121 Tijeras

**Re: State of New Mexico Environment Department-Springer Building
(Resubmittal)
121 Tijeras Ave. NE
Traffic Circulation Layout
Engineer's/Architect's Stamp dated 7-2-15 (K14-D036)**

**Re: State of New Mexico Environment Department-Springer Building
121 Tijeras Ave. NE
Traffic Circulation Layout
Engineer's/Architect's Stamp dated 6-23-15 (K14-D036)**

**Re: State of New Mexico Environment Department-Springer Building
121 Tijeras Ave. NE
Traffic Circulation Layout
Engineer's/Architect's Stamp dated 4-20-15 (K14-D036)**

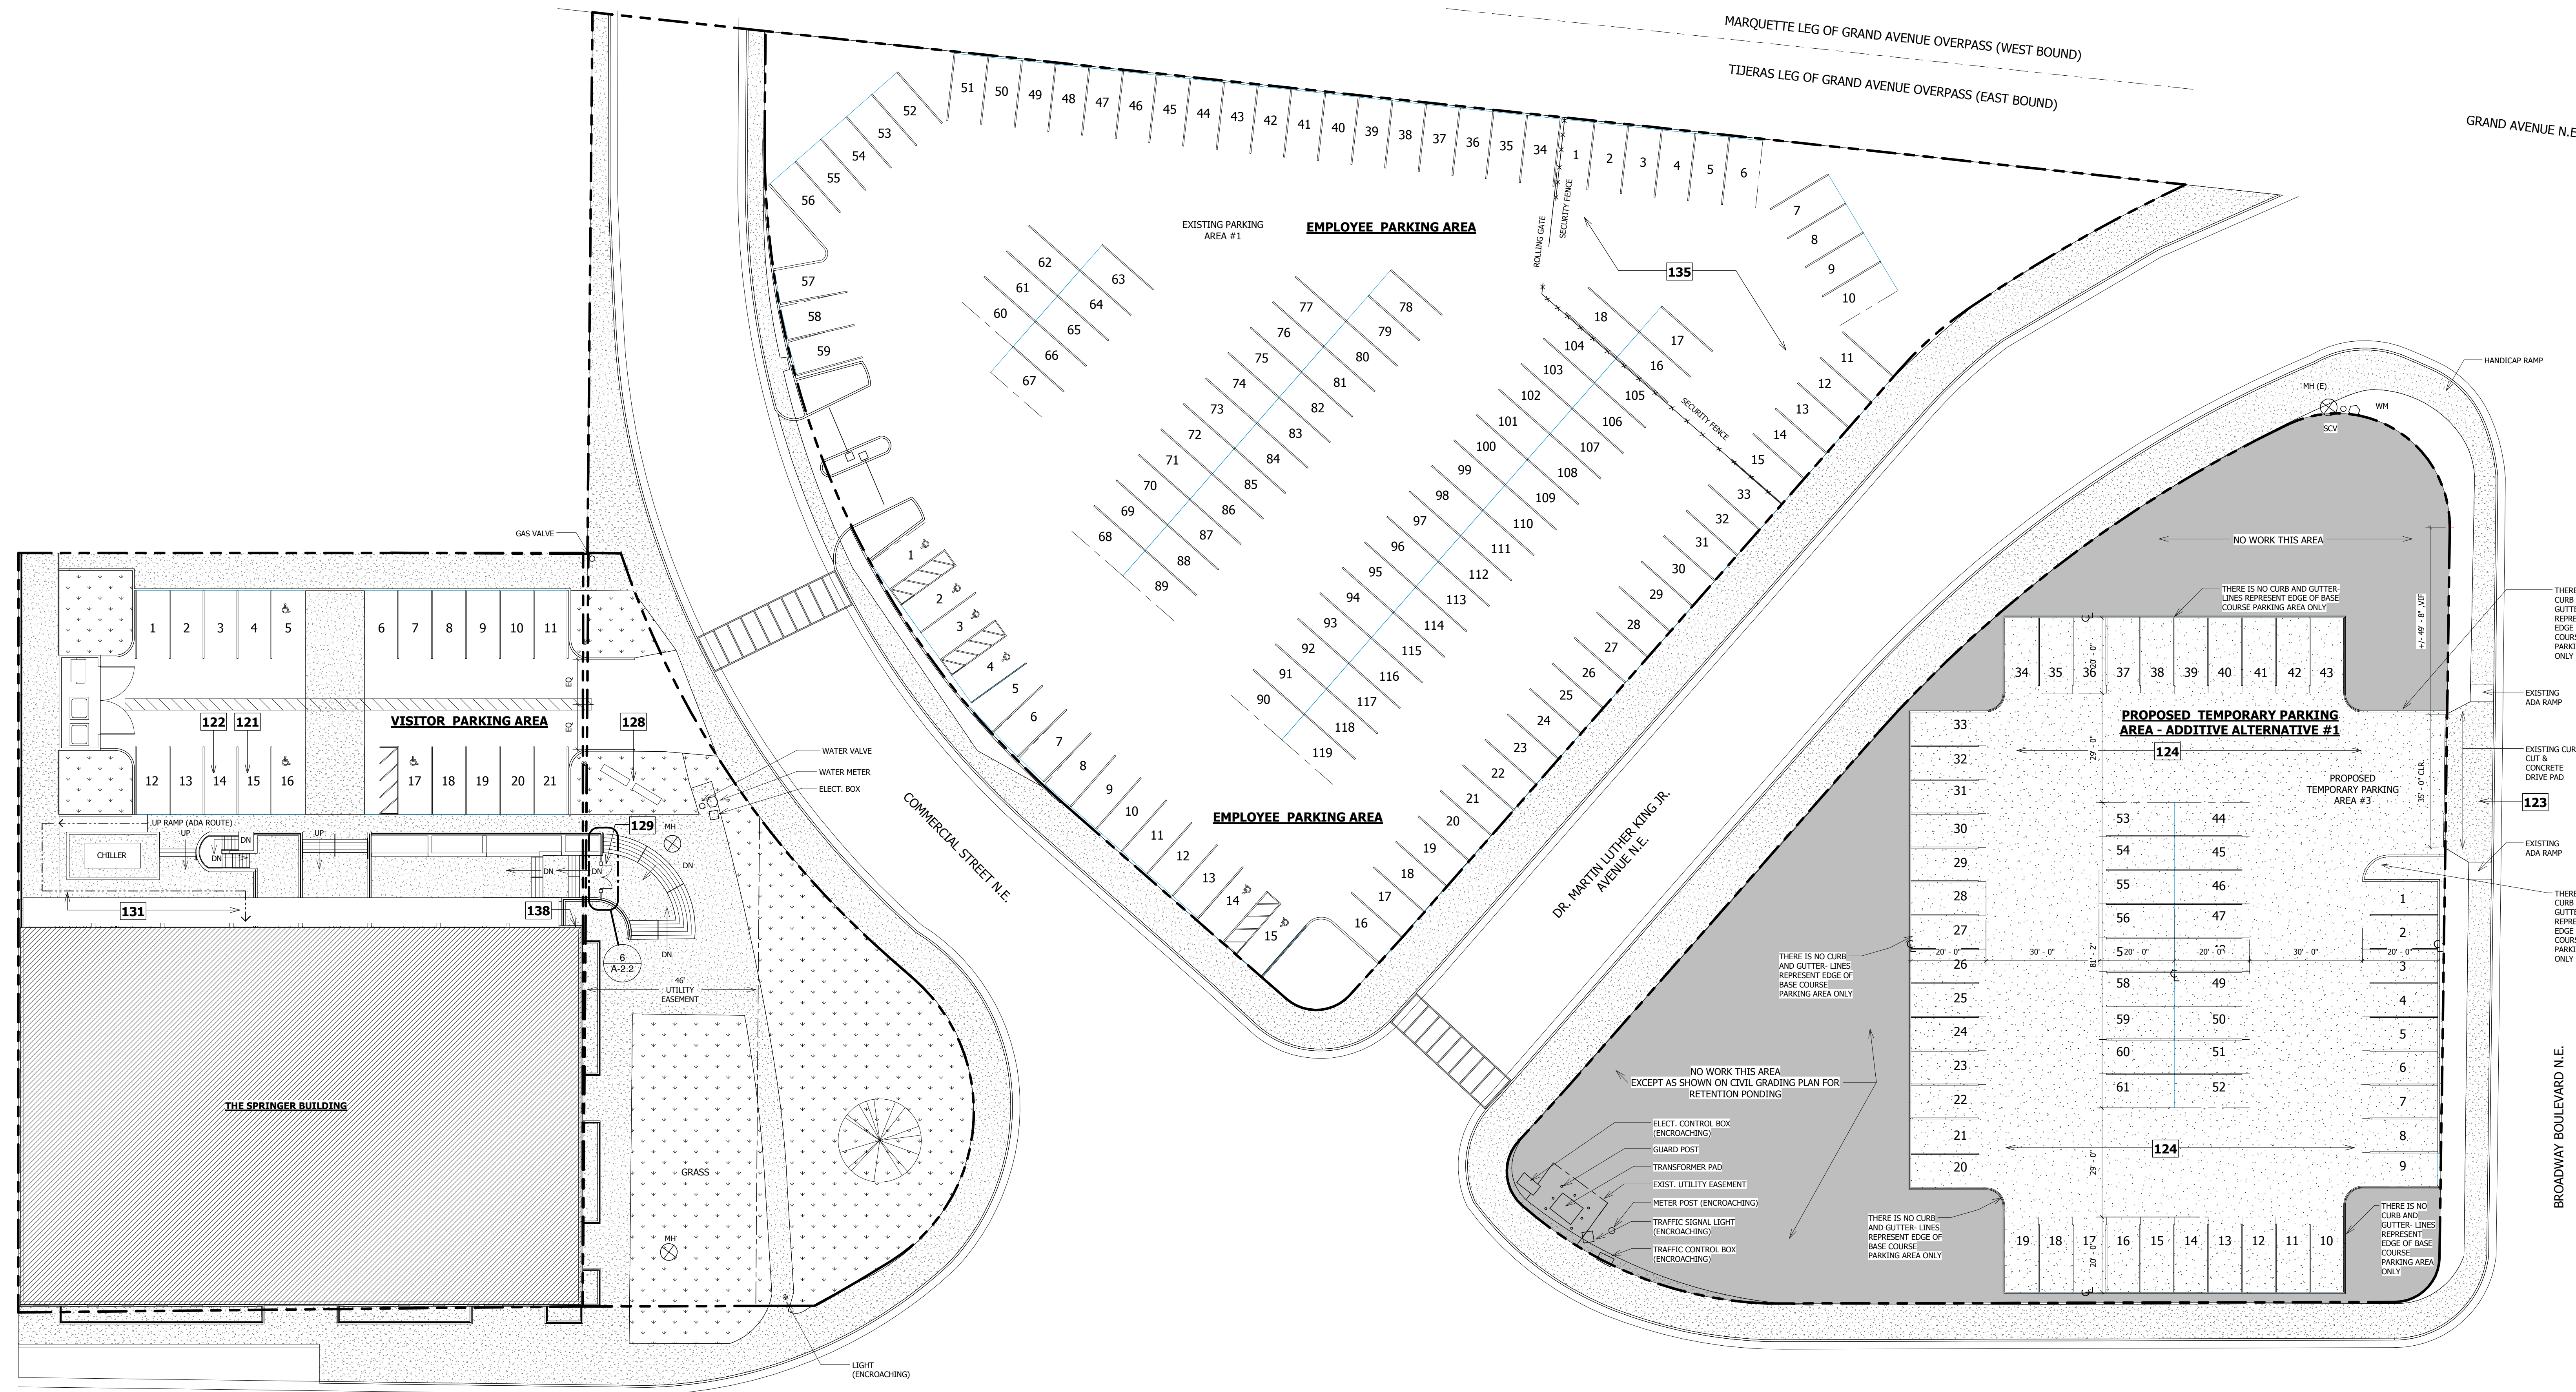
1. Please show a vicinity map showing the location of the development in relation to streets and well known landmarks.
2. Label new lot as "Overflow Parking".

3. Clarify the extents of the current phase. Please label existing buildings.
4. Please clarify the use of temporary parking. Is it be used just during construction?

5. Please identify all existing buildings, doors, structures, sidewalks, curbs, drive pads, walls and anything that influences the parking and circulation on the site.

6. Identify all existing access easements and rights of way with dimensions.
7. Identify the right of way width, medians, curb cuts, and street widths on Tijeras Ave., Dr. Martin Luther King Jr.Ave., and Commercial St.

8. The lot must be graded and surfaced with blacktop or equal: Two inches of asphalt concrete on a prime coat over a four inch compacted subgrade, or a surface of equal or superior performance characteristics. If street curbs and gutters exist adjacent to the parking lot property on a side where lot egress is allowed, the surfacing shall be blacktop for the width of the egress drive(s) and shall extend inward from the property line a minimum of 25 feet along all normal lines of egress traffic flow from the lot. All paving shall be maintained level and serviceable (i.e. no potholes). The City Engineer will have to approve a grading and drainage plan before the asphalt can be installed.

9. For parking lots of 20 or fewer spaces: A layer at least two inches thick of gravel sized from 3/8 minimum to one inch maximum diameter, at least ½ inch of which shall be maintained on the surface; gravel shall be kept off the right-of-way.

10. A parking lot shall include landscaping planted and maintained according to a Landscaping Plan approved by the Planning Director; however, the Planning Commission may waive this requirement where it is found not useful to achieving the intent of this Zoning Code.

11. The lot shall have barriers which prevent vehicles from extending over the sidewalk or abutting lots, or beyond the sides of a parking structure. The plans do already address providing concrete vehicular wheel stops.

12. Please list the width and length for all existing and proposed parking spaces. Please clearly detail how each parking space is to be marked and if there will be curb stop or car parking bumpers installed in each parking space. The minimum parking space width is 8.5 ft.

13. The ADA van accessible sign must have the required language per 66-7-352.4C NMSA 1978 **"Violators Are Subject to a Fine and/or Towing."** Please show a detail of the existing ADA signs.

14. The ADA access aisle shall have the words **"NO PARKING"** in capital letters, each of which shall be at least one foot high and at least two inches wide, placed at the rear of the parking space so as to be close to where an adjacent vehicle's rear tire would be placed. (66-1-4.1.B NMSA 1978)

15. Show all drive aisle widths and radii.
16. List radii for all curves shown; for passenger vehicles, the minimum end island radius is 15 feet. Landscape island radius for delivery trucks, fire trucks, etc. is 25 feet or larger

17. Per the DPM, a 6 ft. wide ADA accessible pedestrian pathway is required from the public sidewalk to the building entrances. Please clearly show this pathway and provide details from the proposed temporary parking.

18. Per the DPM, a 6 ft. wide ADA accessible pedestrian pathway is required from the HC parking stall access aisles to the building entrances. Please clearly show the ADA pedestrian pathway from the existing and proposed parking to the building entrance.

19. Provide a min 6" or max 8" high concrete barrier curb or other acceptable barrier between landscaping and parking areas and/or drive aisles.
20. Please provide a sight distance exhibit for entrance off of Broadway Blvd. (see the *Development Process Manual, Chapter 23, Section 3, Part D.5 Intersection Sight Distance*).

21. Please add the following note to the clear sight triangle: "Landscaping and signage will not interfere with clear sight requirements. Therefore, signs, walls, trees, and shrubbery between 3 and 8 feet tall (as measured from the gutter pan) will not be acceptable in this area."
22. Please specify the City Standard Drawing Number when applicable.
23. Work within the public right of way requires a work order with DRC approved plans.
24. See Chapter 23, Section 6 of the City of Albuquerque *Development Process Manual*, for appropriate drive pad widths.
25. Please include two copies of the traffic circulation layout at the next submittal.
